**1865  
WOODMOOR  
DRIVE  
MONUMENT  
COLORADO**

SITE TITLE

**E-1**  
5 OF 6

# Markup Summary

SITE PHOTOMETRIC DETAILS

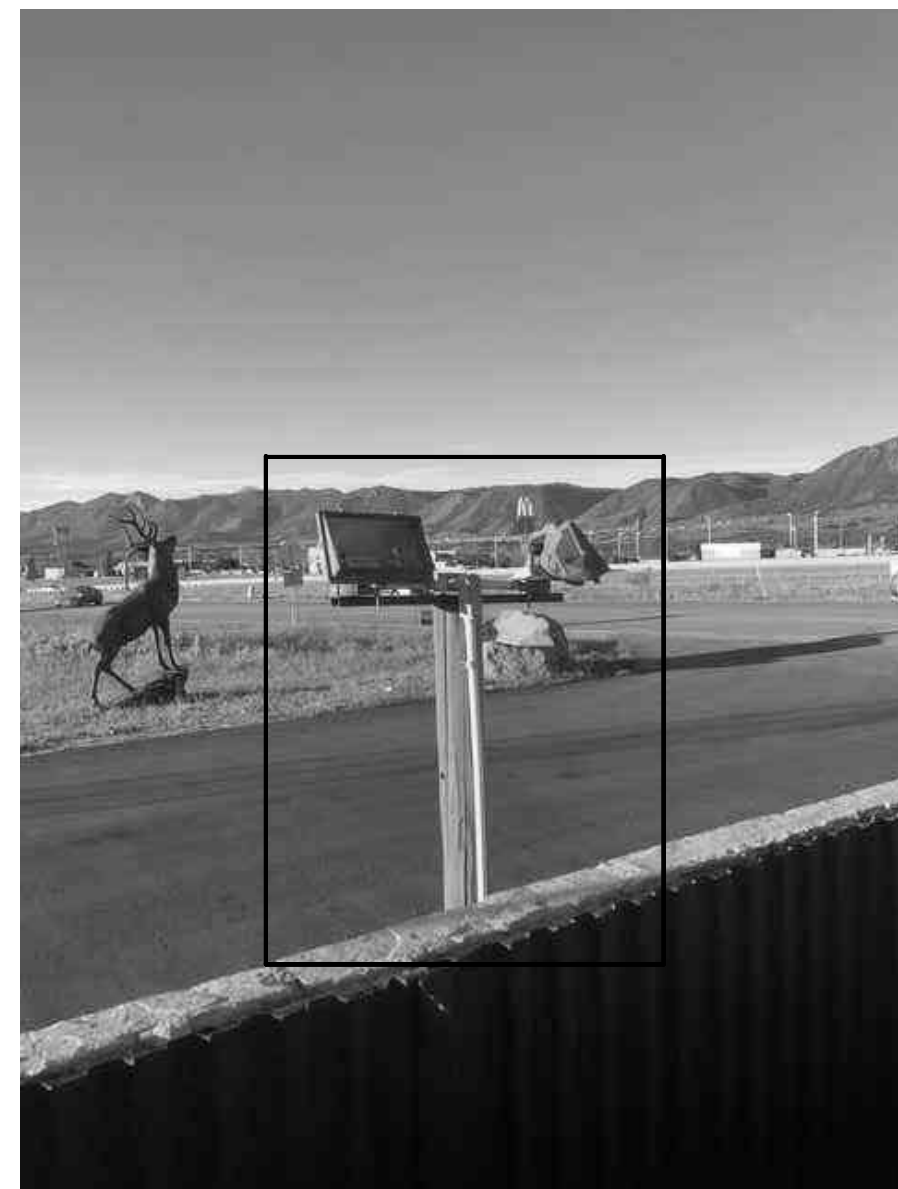
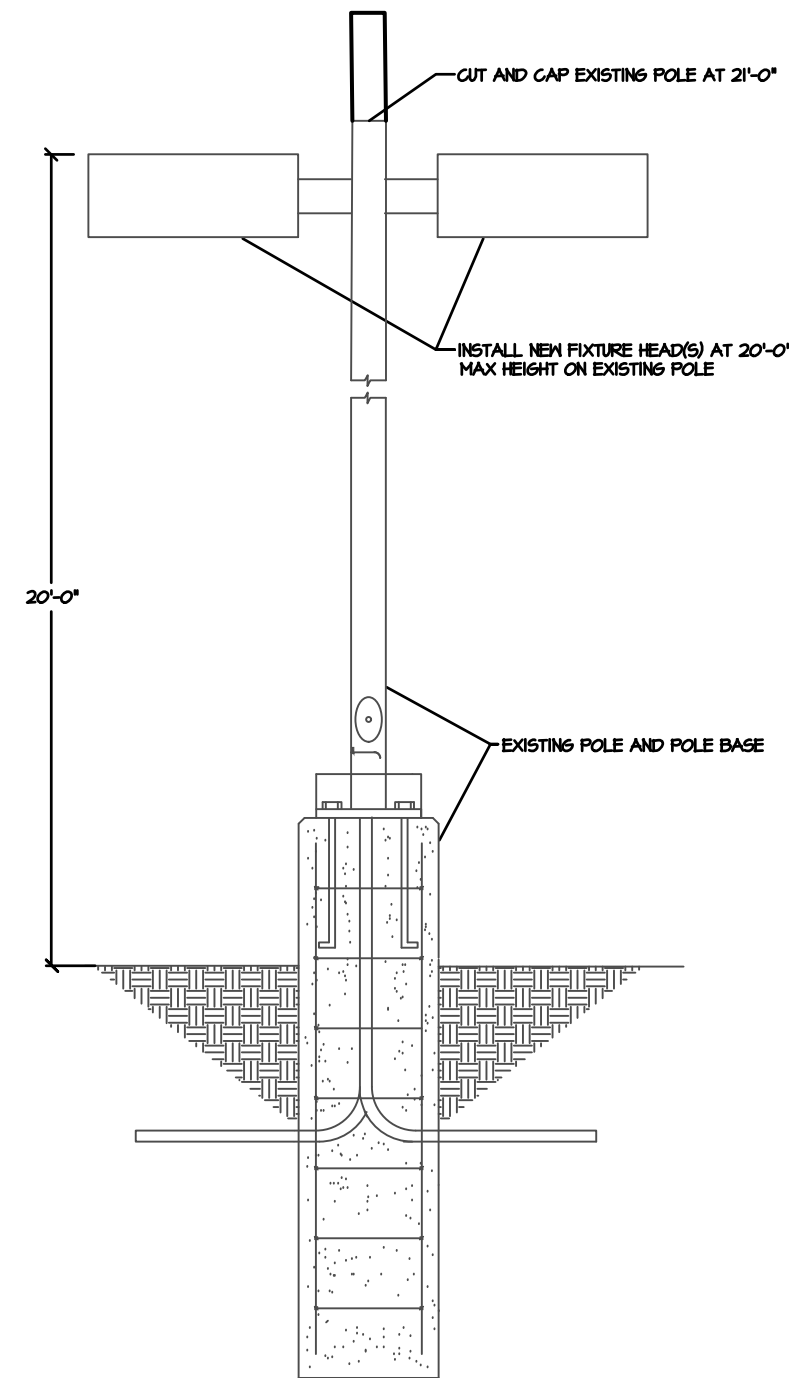
Per 6.2.3.B.2 the pole lights cannot exceed 20 feet in the parking areas. You must request alternative lighting or replace with shorter lights.
